# CITY OF PORTLAND, MAINE

February 3<sup>rd</sup>, 2014

**Project Name:** Residential townhouse - 6 unit condominium  
**Project ID:** 2013-187  
**Project Address:** 133 York Street  
**CBL:** 44-1-29 &31  
**Applicant:** 133 York, LLC, Applicant  
**Planner:** Jean Fraser

On January 28<sup>th</sup>, 2014 the Portland Planning Board considered and approved a Level III Final Site Plan and Subdivision proposal for the construction of a 6 unit residential building at 133 York Street.

PLAN 3

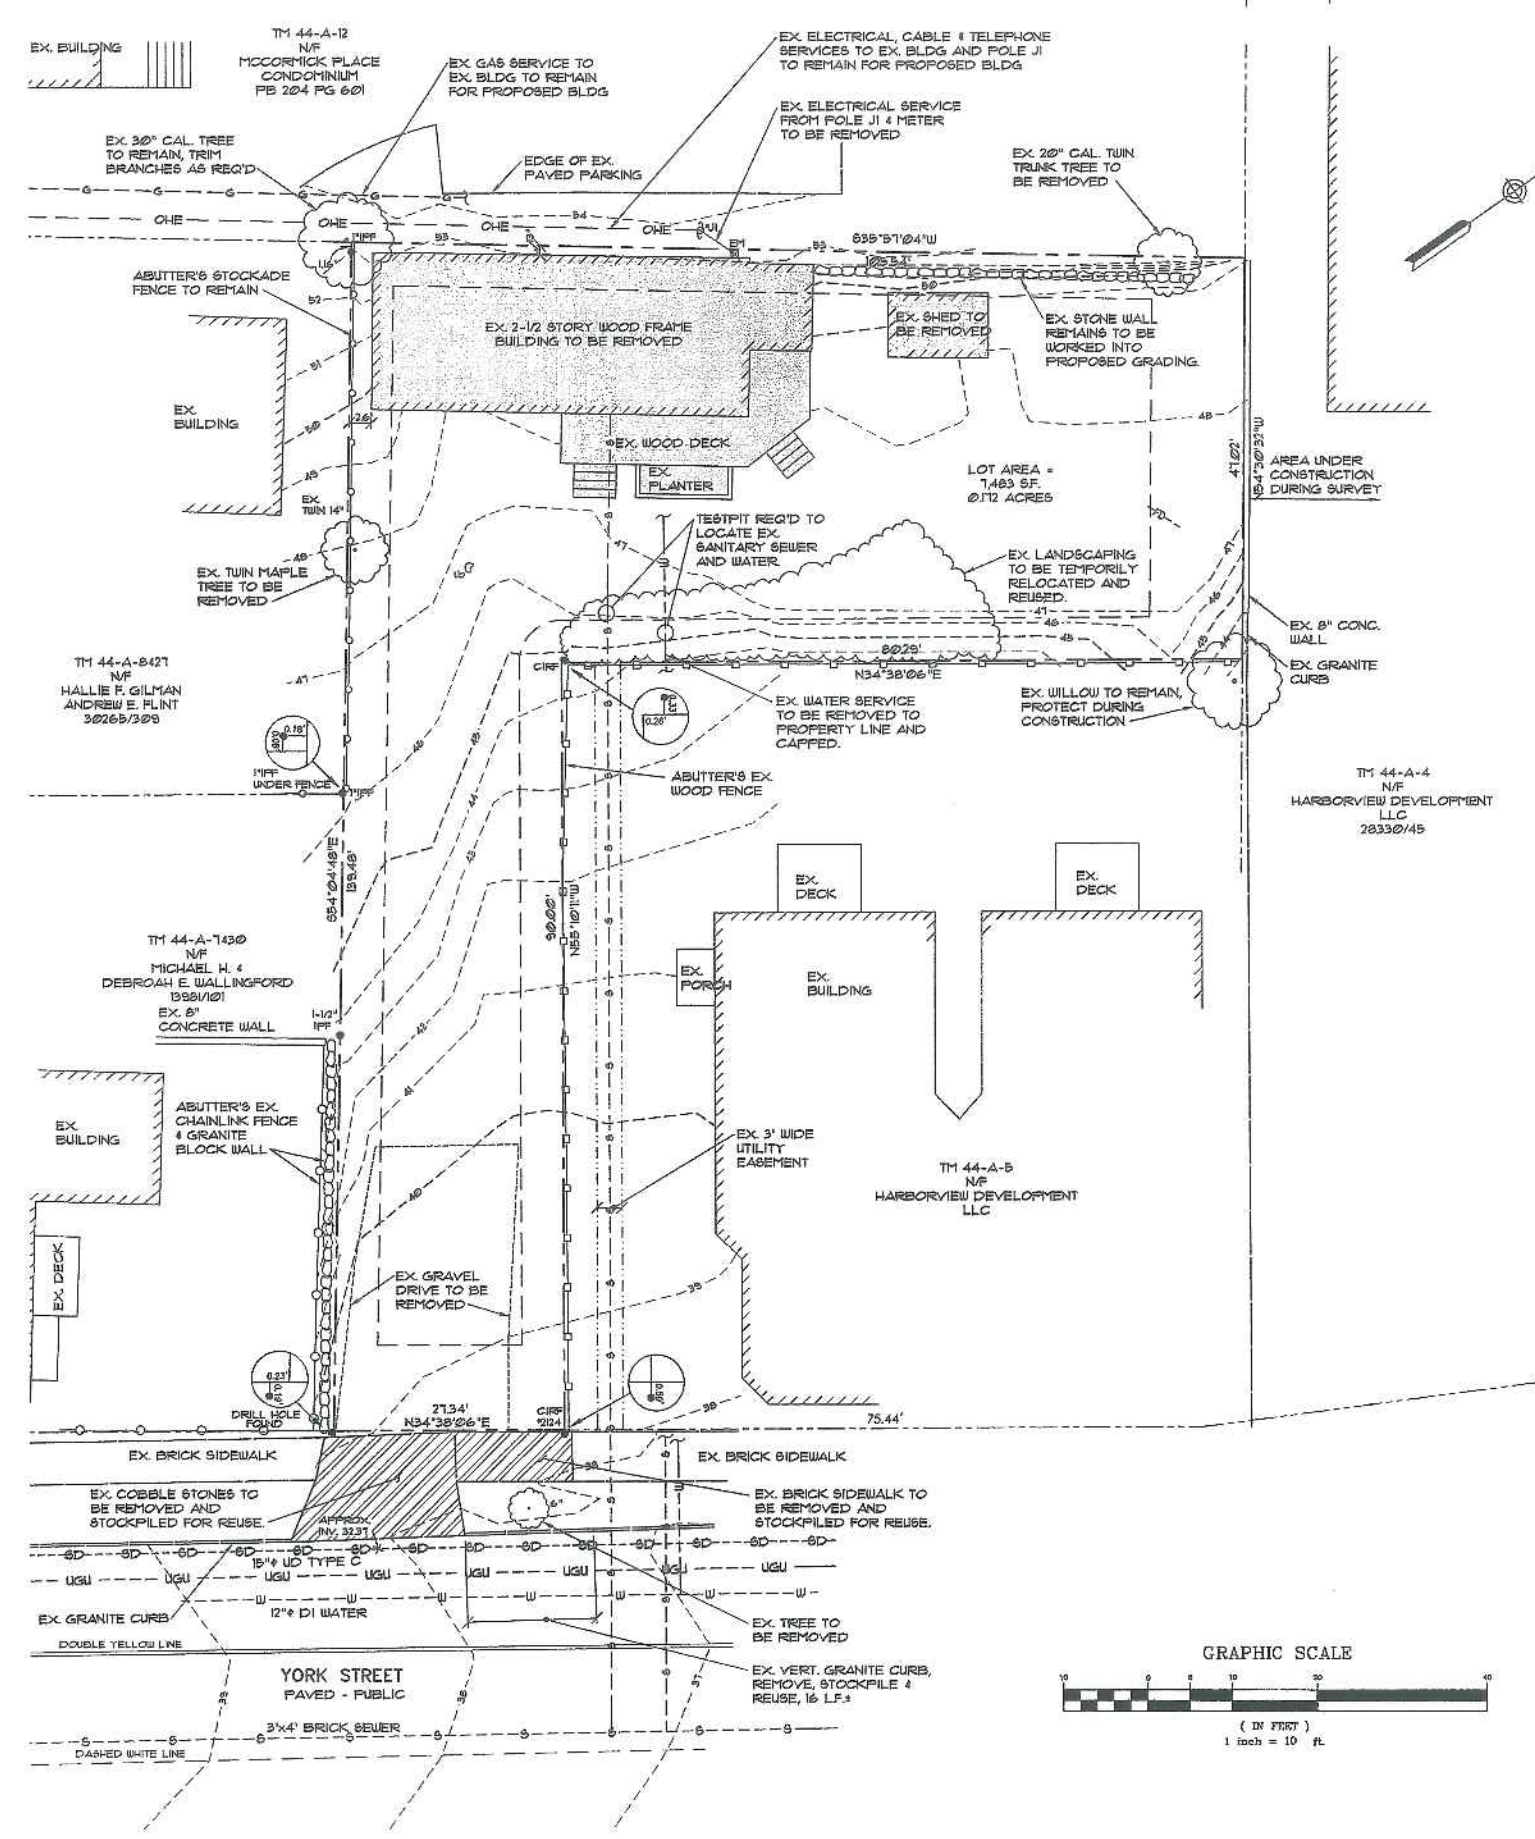
1. The Planning Board voted 6-0 (Dundon absent) to waive the Ordinance Section 14-526 (b) (2) (b) (iii) Street Trees to allow for a contribution of \$600 to the City's Street Tree Fund to be substituted for the provision on site of three of the required street trees.
2. The Planning Board voted 6-0 (Dundon absent) to waive the Technical Design Standard Section 1.14 *Parking Lot and Parking Space Design* to allow a drive aisle of less than 24 feet , as shown on Plan P3 subject to the requirement that the bike rack be relocated.

- vi. That the applicant shall reconsider the location of the bicycle parking rack so that it does not impede access to parking spaces and is readily visible and accessible to potential users, with a plan showing the revised location to be reviewed and approval by the Planning Authority prior to the issuance of a building permit; and

PLANT LIST

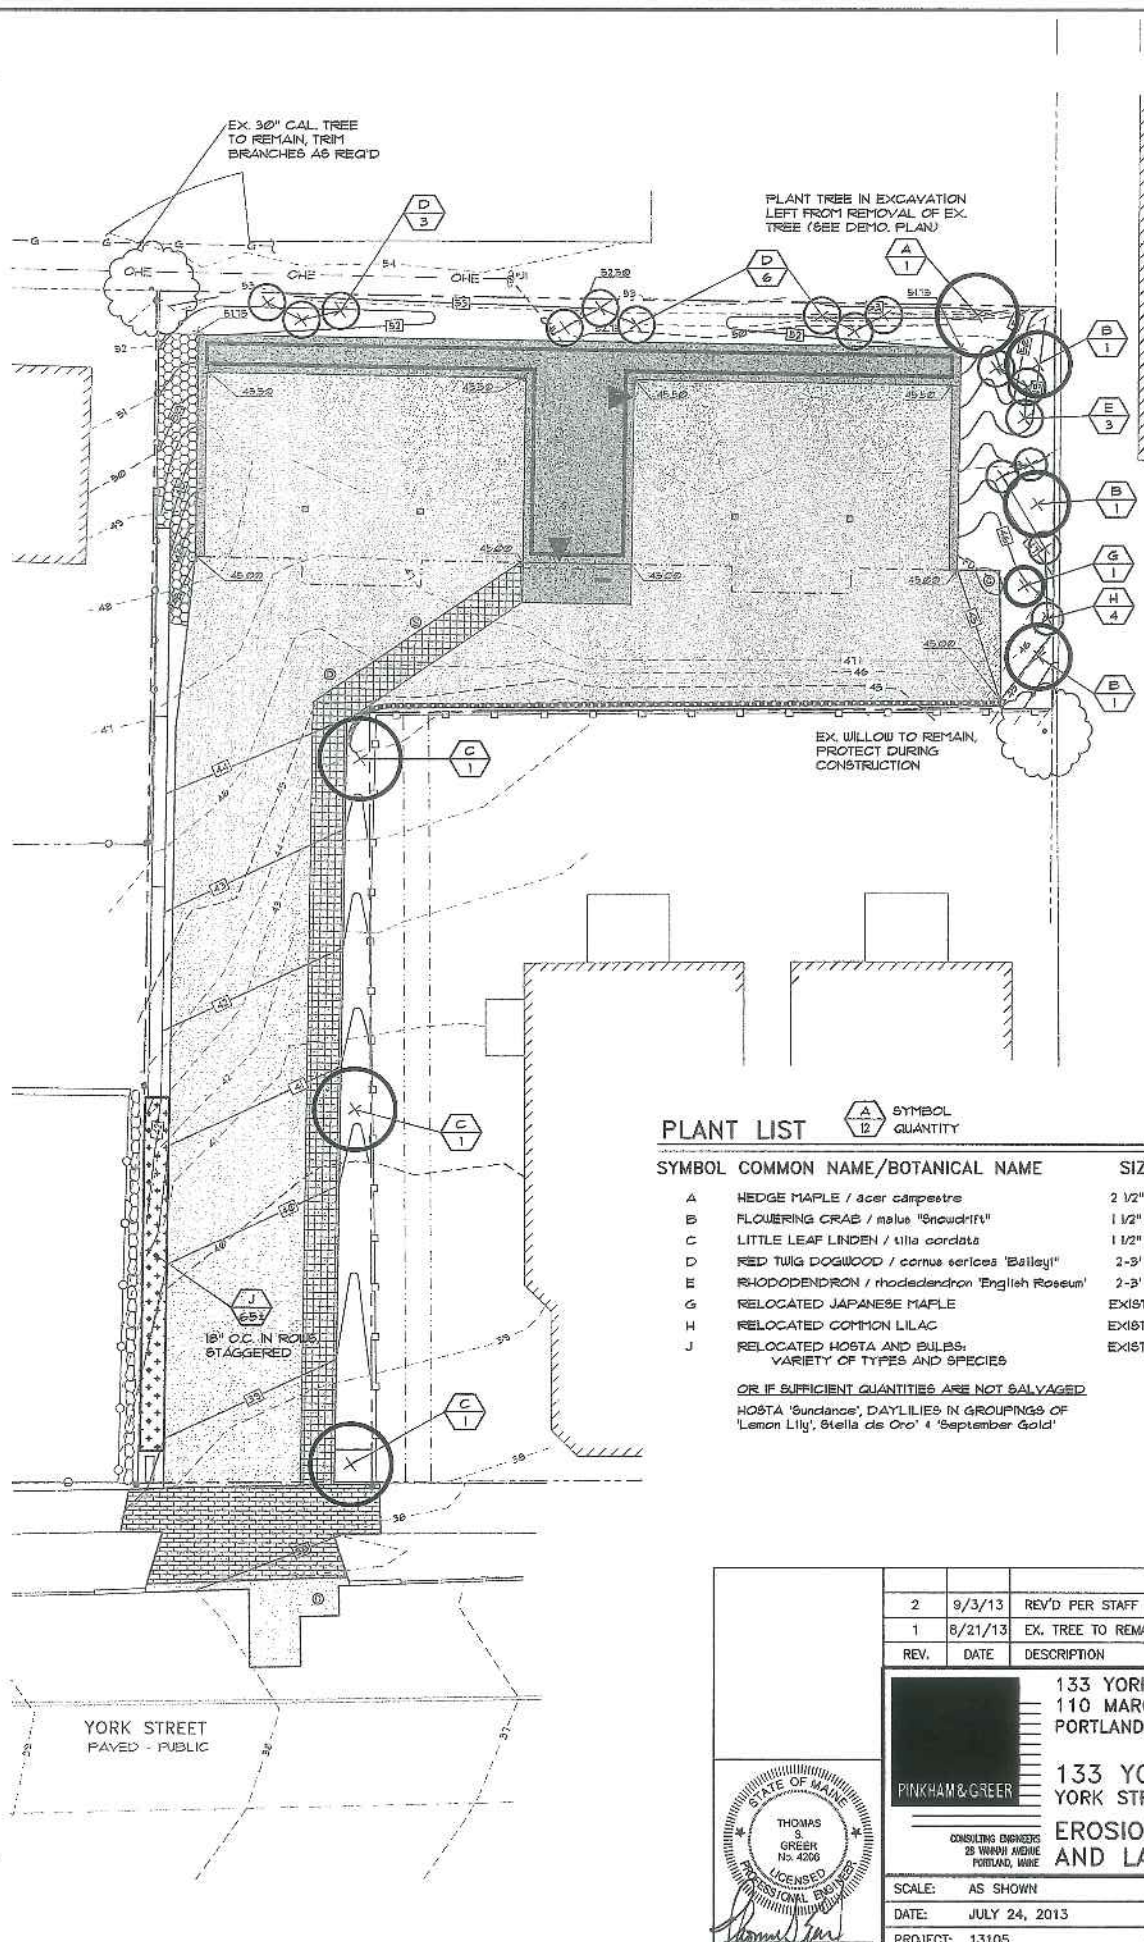
**b) landscape plant material: plant sizes - Condition)** shrub stock noted as "D" Clethra, "F" Deutzia, "J" Northern Bayberry, "K" Climbing Hydrangea, "L" Stephanandra shall all be #3 pot size minimum and tree sizes should be the following: "B" Flowering Crabapple 1.75-2" caliper, "C" Armstrong Red Maple 2" caliper. Items mentioned as "Existing", "G" Relocated Japanese Maple (#5 pot size), "H" Relocated Lilac (3-4'H) should also have these sizes as replacements if the relocation is not successful. (Too often good intent to save plants through construction are less then successful).

**c) Green wall** - the proposed project use of a green wall will help screen / buffer the adjacent building. The green wall plant type: Climbing Hydrangea is slow growing, and thus the proposed 1 gallon pot size much to small to be effective for many years... recommendations & condition the green wall plant sizes must be #3 pot & #5 pot sizes alternating minimum to provide a good start for the green wall.
